**Submission on the Environmental Impact Statement for the Berrima Hotel  
(SSD-66876472)**

Wingecarribee Shire Council welcomes the opportunity to provide a submission during the public exhibition period for the Berrima Hotel proposed adaptive re-use of the former Berrima Gaol at 2-4 Argyle Street, Berrima.

Berrima Hotel State Significant Development Application (SSD-66876472)

1 West Elevation_Wingecarribee River
1:250

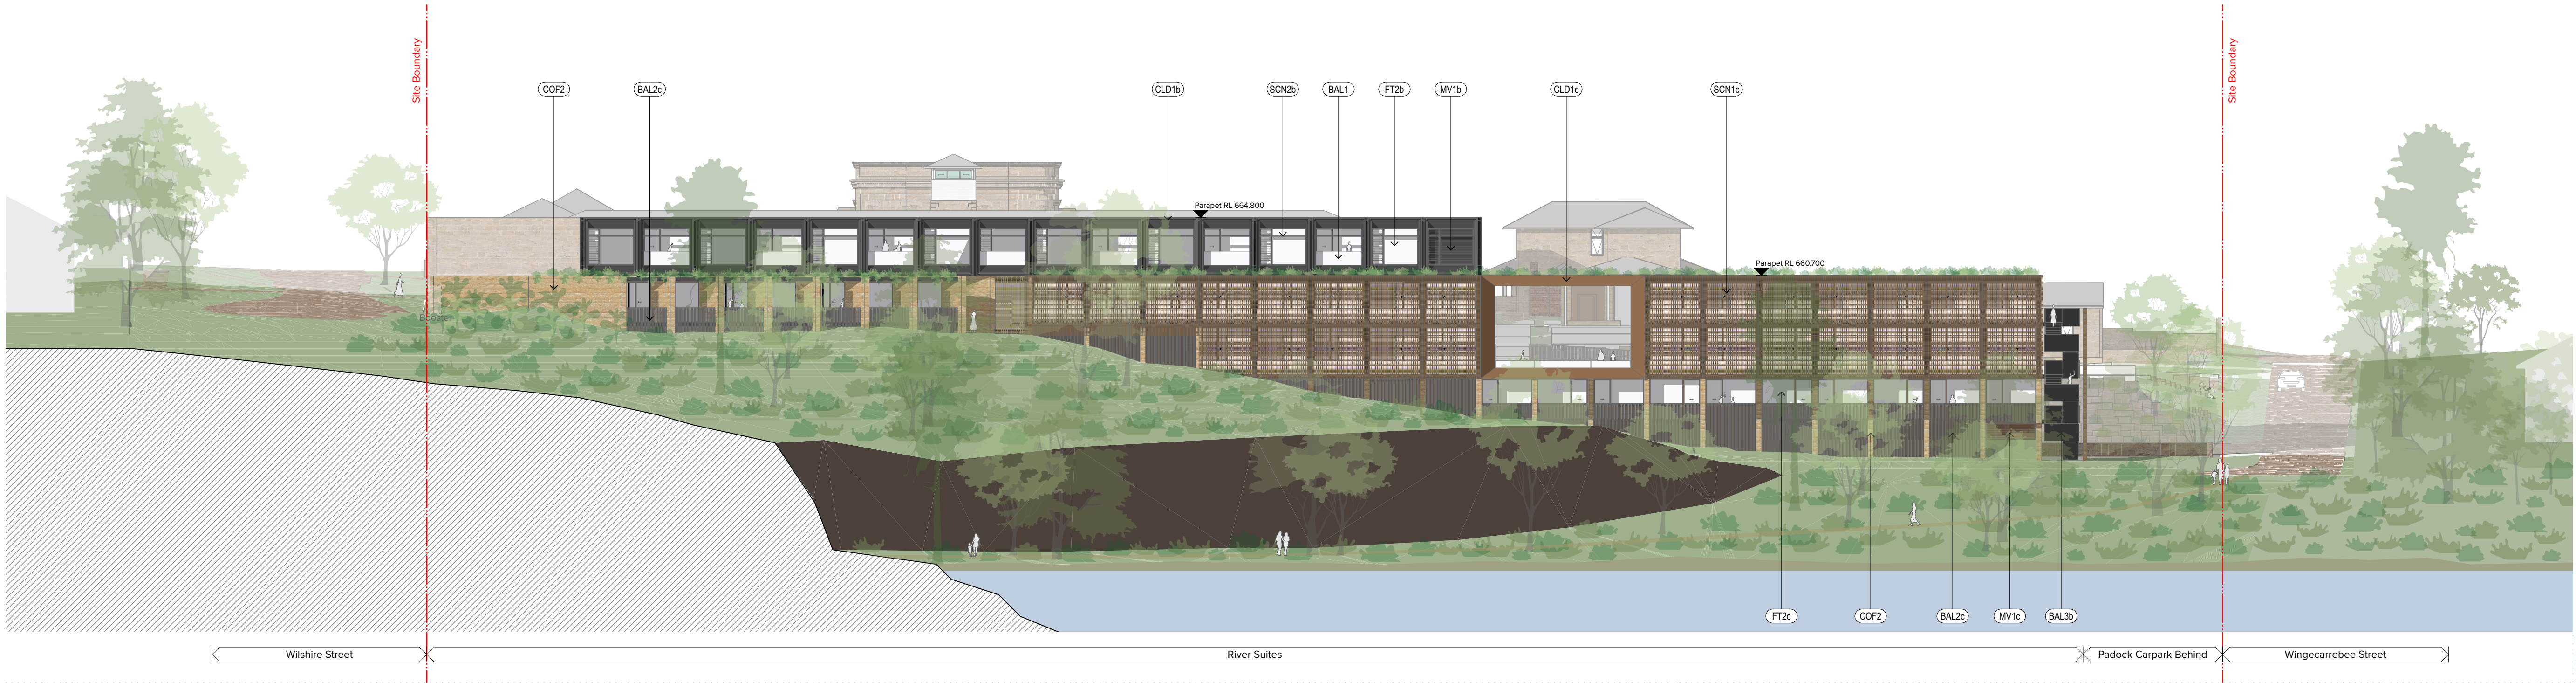
The proposed three-storey hotel building (River Suites) represents a substantial visual intervention on the western side of the site. Although the assessment asserts that its location within a topographic low and use of muted materials will mitigate visibility, Council considers the outcome highly dependent on assumptions about vegetation growth, material selection, and roof reflectivity.

Council is concerned that the building's height, massing, and visibility from the Wingecarribee River corridor will undermine the visual dominance of the original gaol walls and alter the low-rise, vegetated character that defines the Berrima Heritage Conservation Area. The building's bulk remains at odds with the fine-grain, human-scaled form of the surrounding village.

As noted in the VIA, the views of the western gaol walls are obstructed by the Industries Buildings, particularly from Wilshire Street, however the massing and visual dominance of this building is significantly less than what is proposed. The consideration of this building and how it is viewed from both Wilshire and Wingecarribee Streets, should be considered in more detail with a reduction in the overall massing and scale.

- Reduction in the height and visual prominence of the River Suites building.
- Enhanced landscape screening and integration along Wingecarribee and Wilshire Street frontages.
- Preparation of a Visual Impact Verification Report at detailed design stage.
- Submission of a Lighting Management Plan prior to construction.
